Charlotte Storm Water
600 East Fourth Street
Charlotte, N C 28202-2844

Rezoning Petition Review

Date of Review: February 24, 2020 (**Revised May 18, 2020**)

Rezoning Petition #: 20-12

SHEET NUMBER
RZ-1

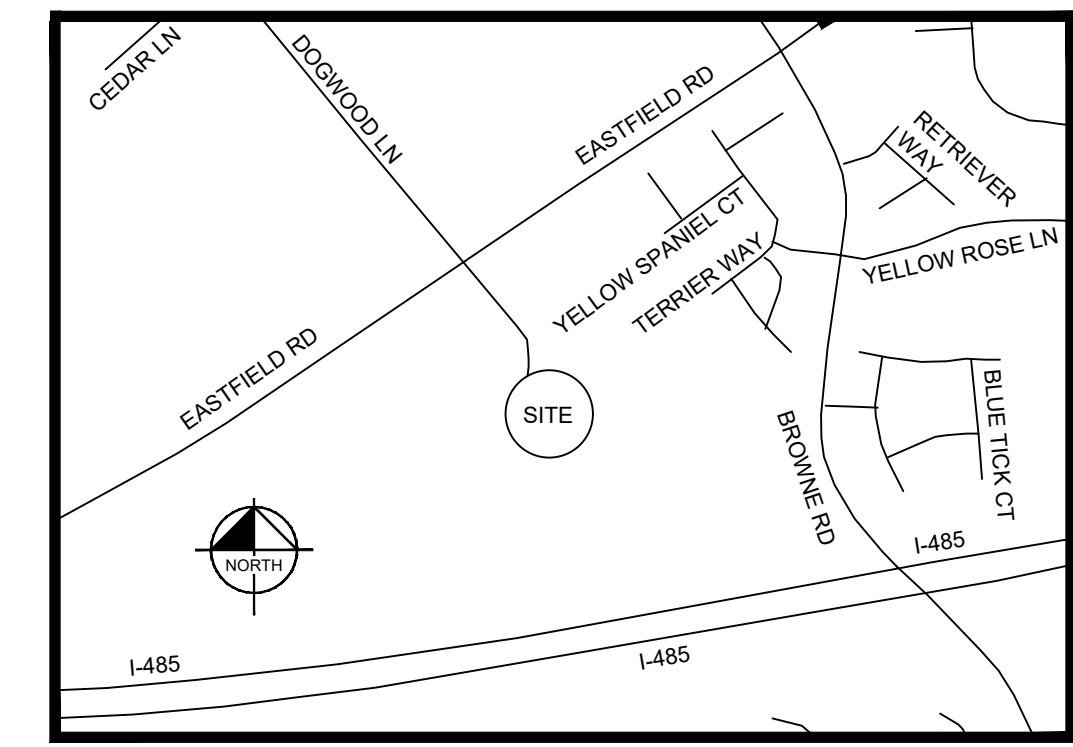
Due to revisions (4/16/20): City of Charlotte GIS data indicates a 100-ft Undisturbed PCSO buffer across the site. Please show and label *Potential 100-ft Undisturbed PCSO Buffer* on the site plan. Any increase of impervious area within such buffers may not be allowed and is not approved with the rezoning process. Stream Delineation Reports are subject to review and approval by Charlotte Storm Water Services. Please include the following note under Environmental Features: *“Development within any SWIM/PCSO Buffer shall be coordinated with and subject to approval by Charlotte-Mecklenburg Storm Water Services and mitigated if required by City ordinance.”*

The proposed rezoning plan sheet indicates a proposed location for storm water management. Please include the following notes on the plan sheet under Environmental Features: *The location, size, and type of storm water management systems depicted on the Rezoning Plan are subject to review and approval as part of the full development plan submittal and are not implicitly approved with this rezoning. Adjustments may be necessary in order to accommodate actual storm water treatment requirements and natural site discharge points.*
